**Application by Fosse Green Energy Park Limited for an Order Granting Development Consent for the Fosse Green Energy Park Project.
Deadline 6 Submissions for Lincolnshire County Council (LCC)**

LCC comments on Deadline 5A documents

Technical Memorandum 9 (AAH TM09)

Lincolnshire County Council and North Kesteven District Council, Fosse Green Energy: Deadline 5A document review

Indicative PV Array Cross-Sections

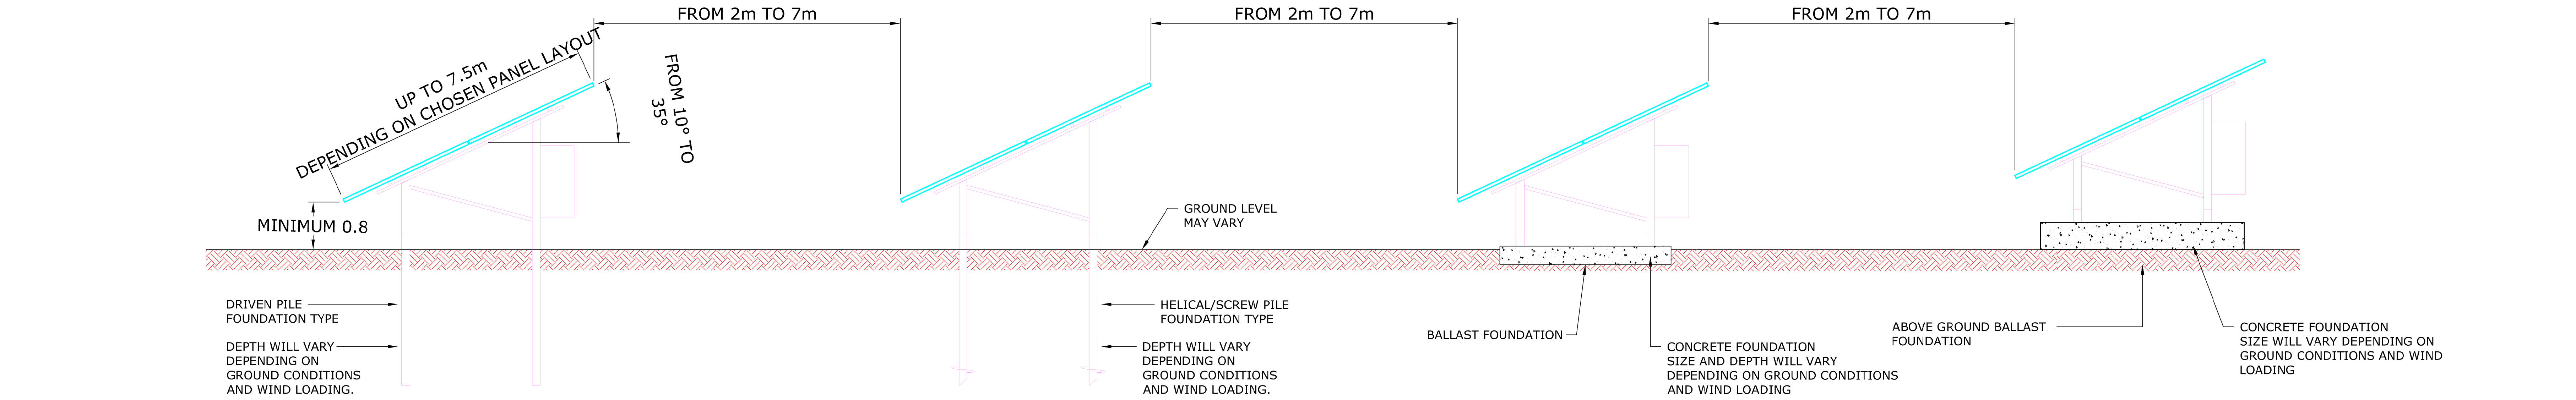
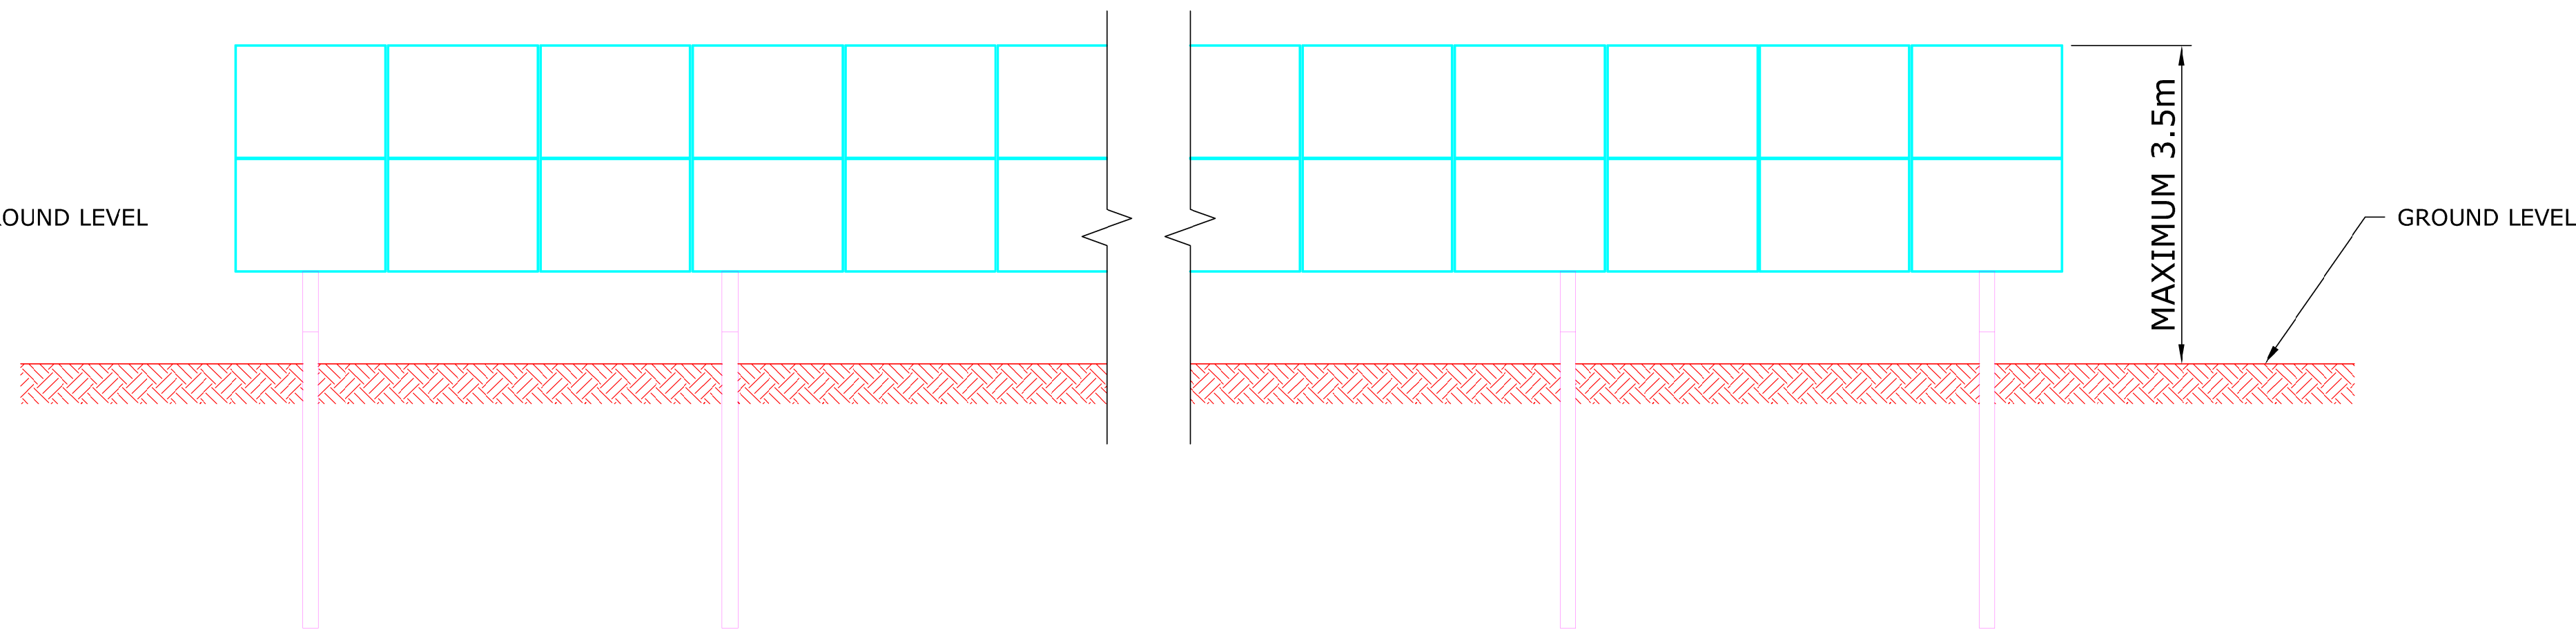
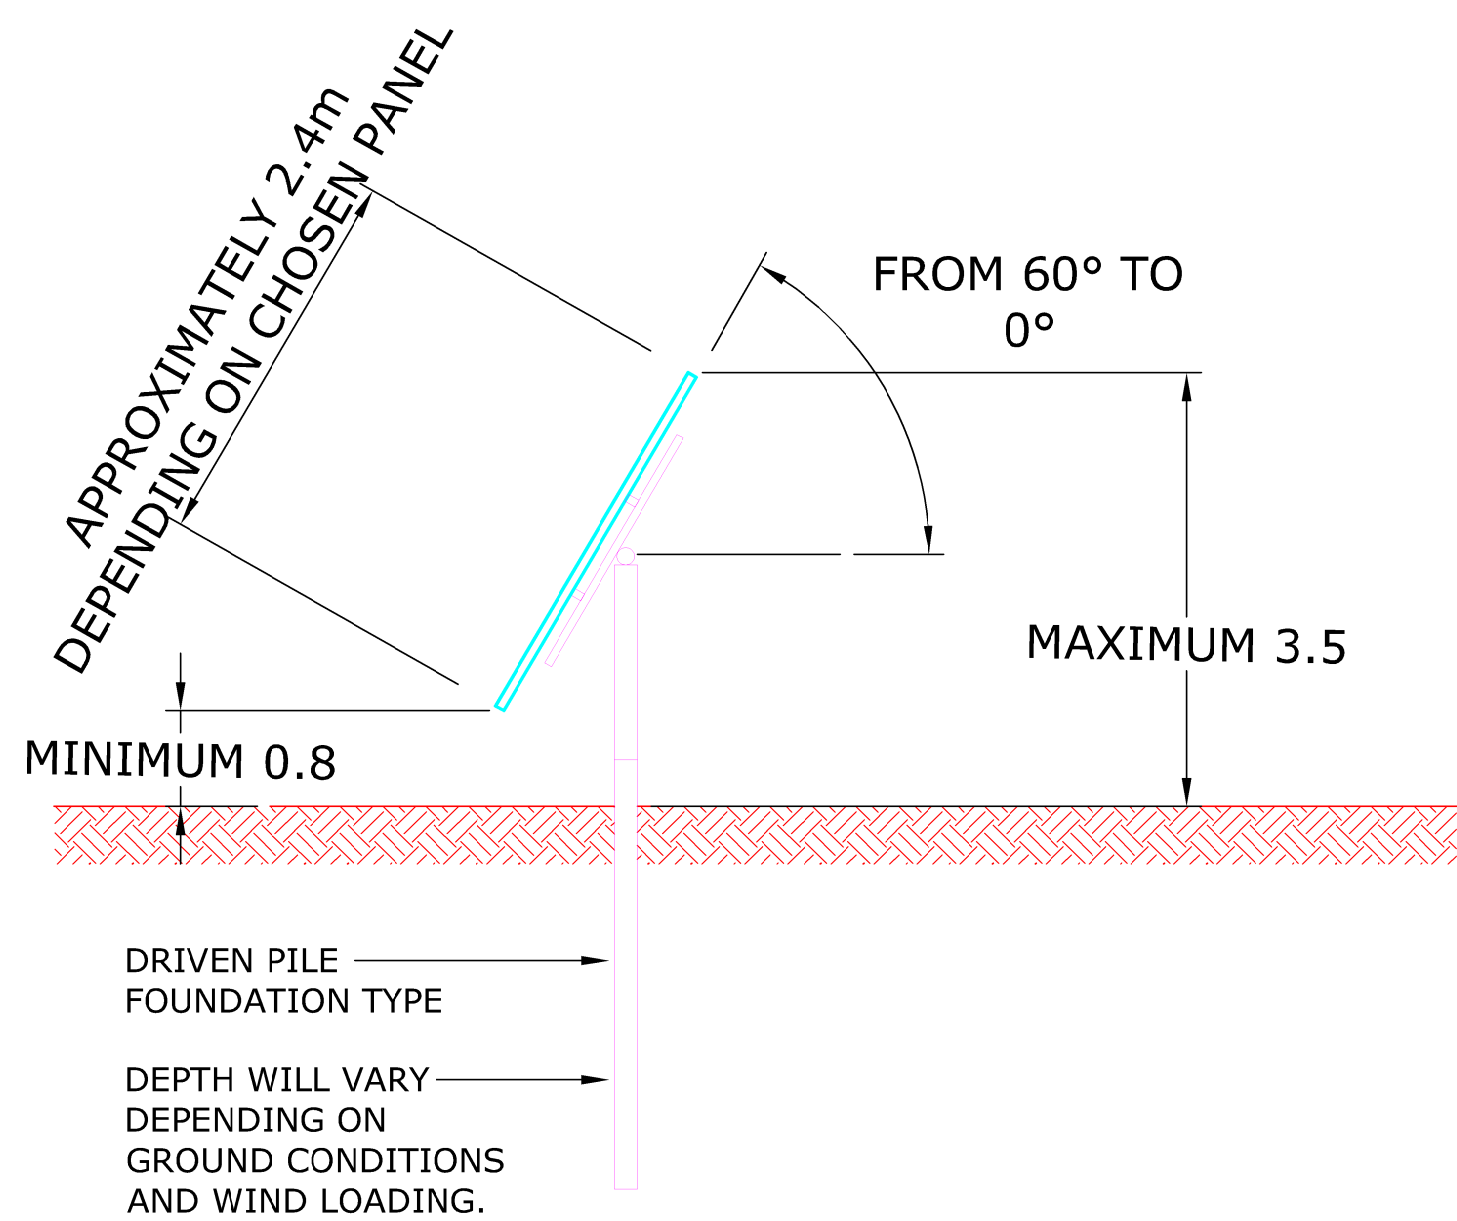
P6 – PV modules possibly ‘blue’ in colour

Further clarification of colour proposed for development structures is required. It should be made clear if the same colour is proposed for all components or not. LCC would suggest neutral colours are given preference – black or dark grey. White, green and blue should be avoided.

Solar Perimeter Fencing

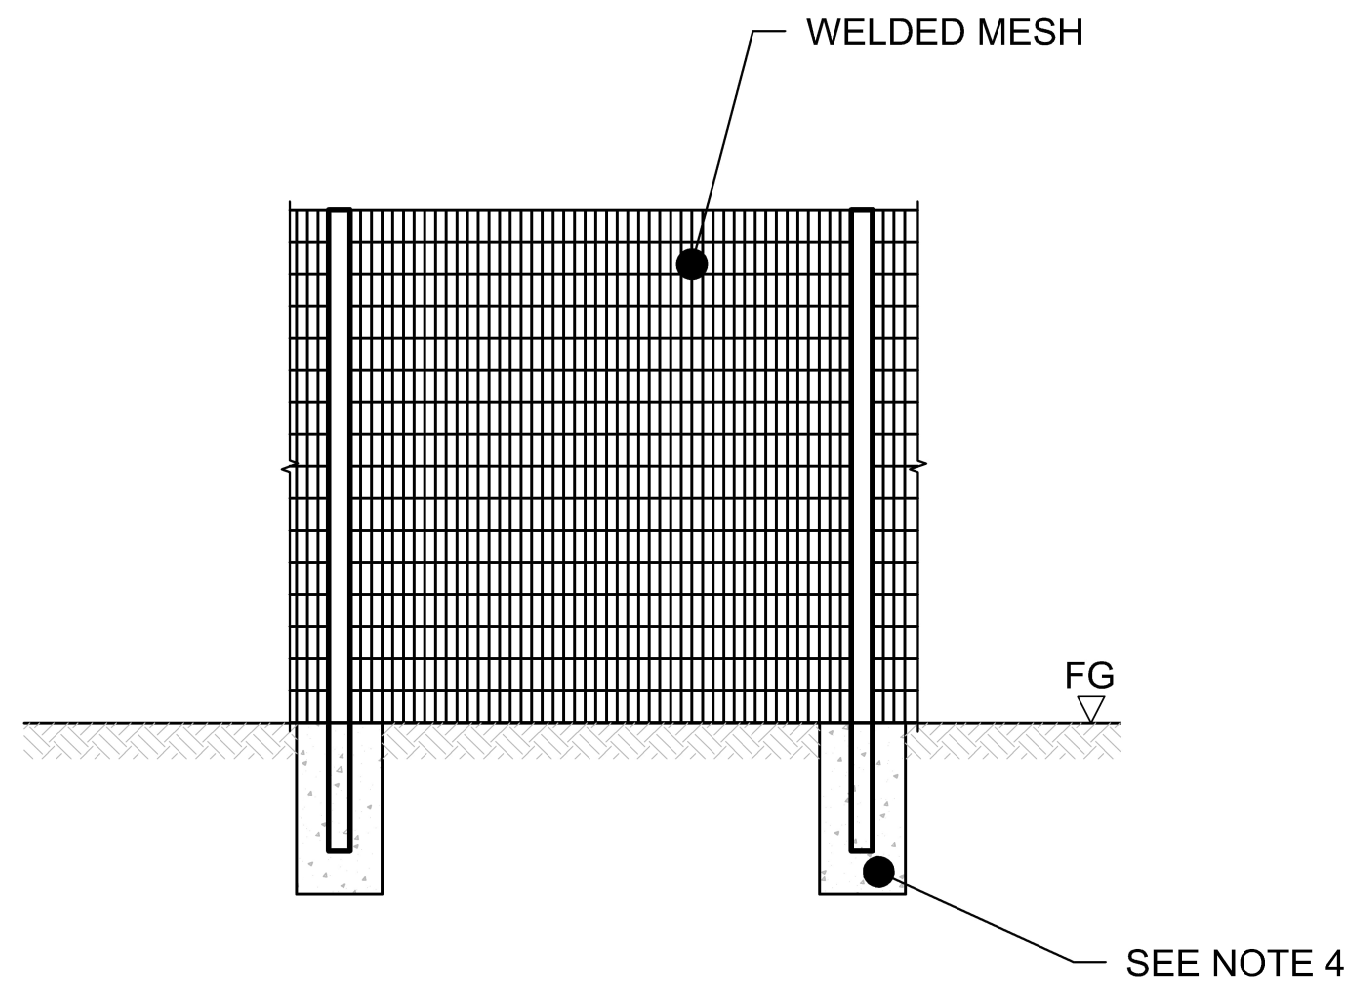
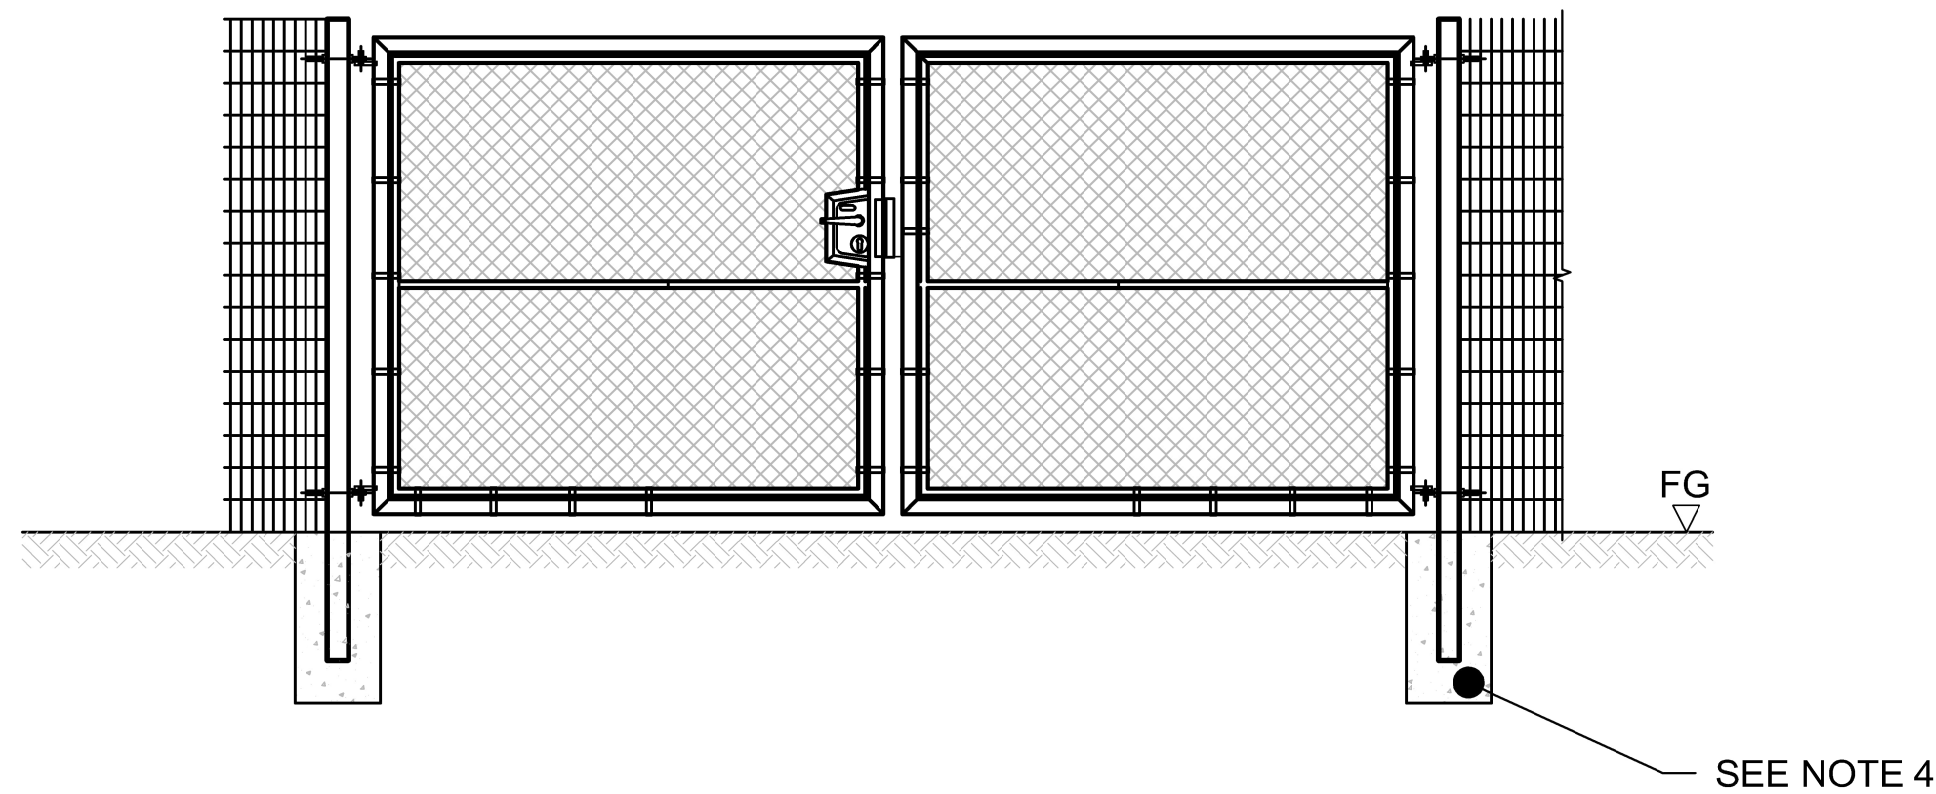
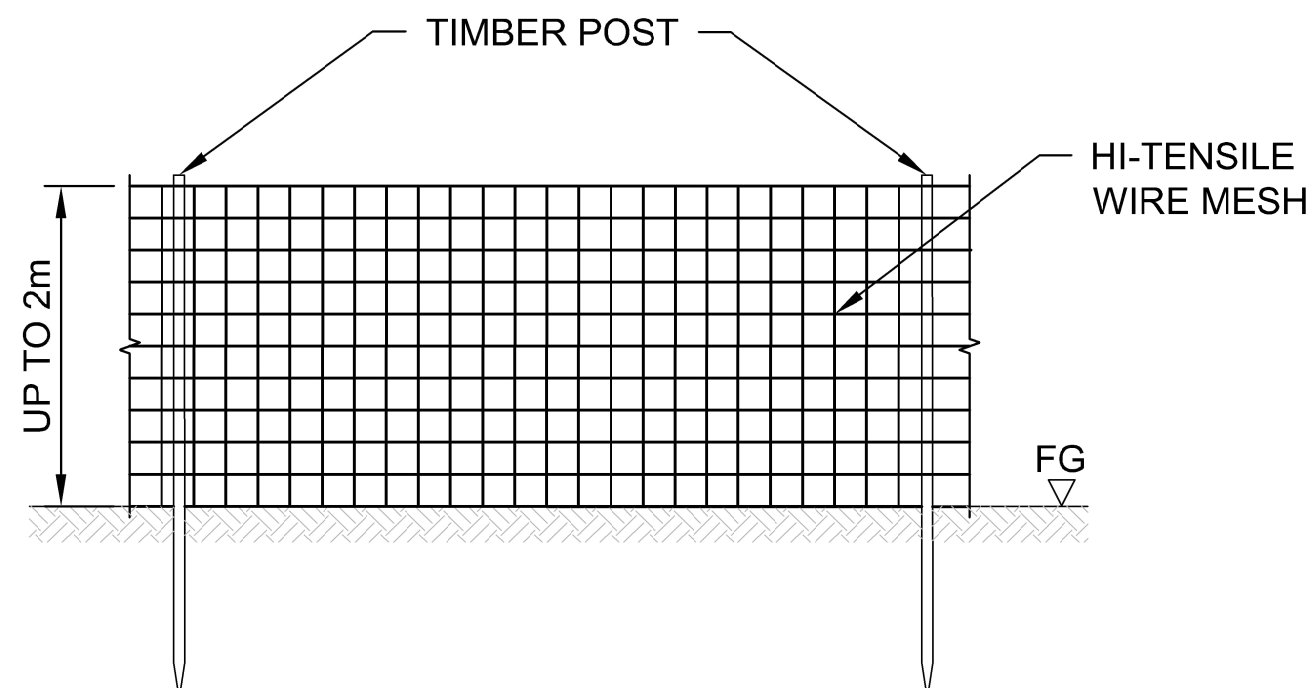
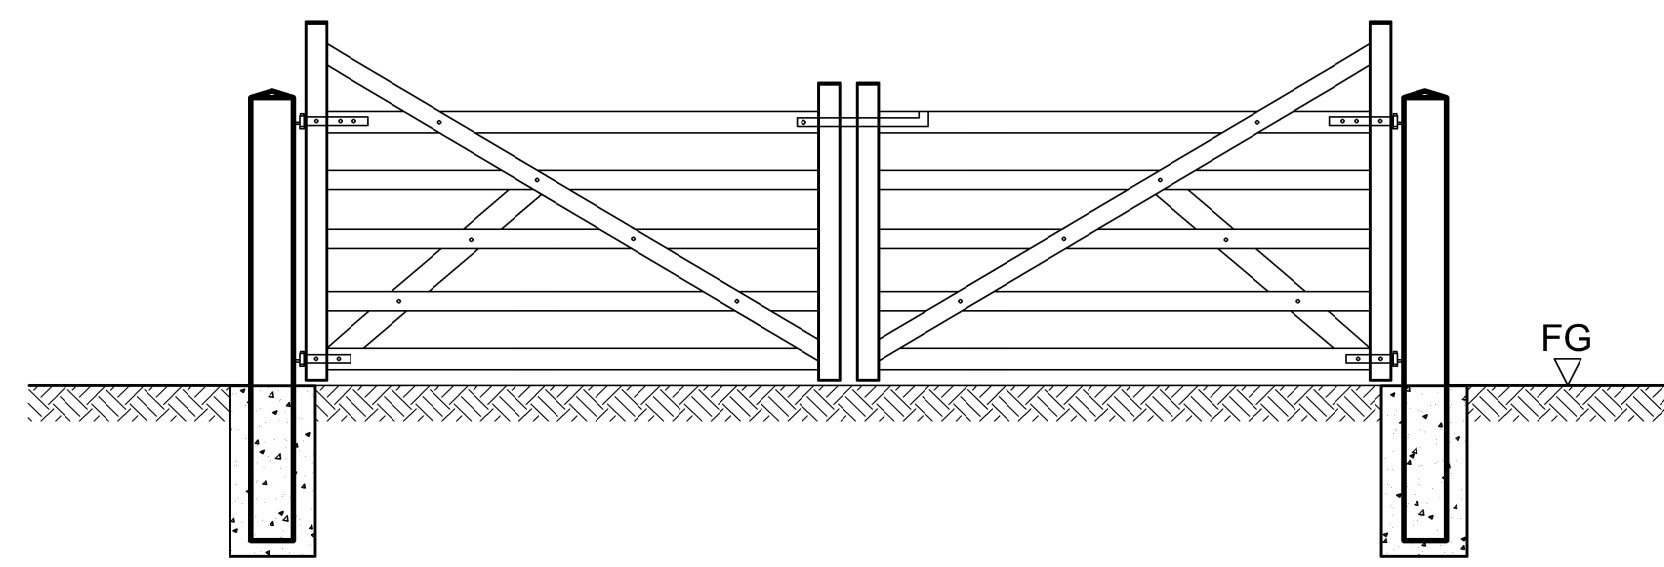
P12 – fencing and containers in ‘muted’ colour
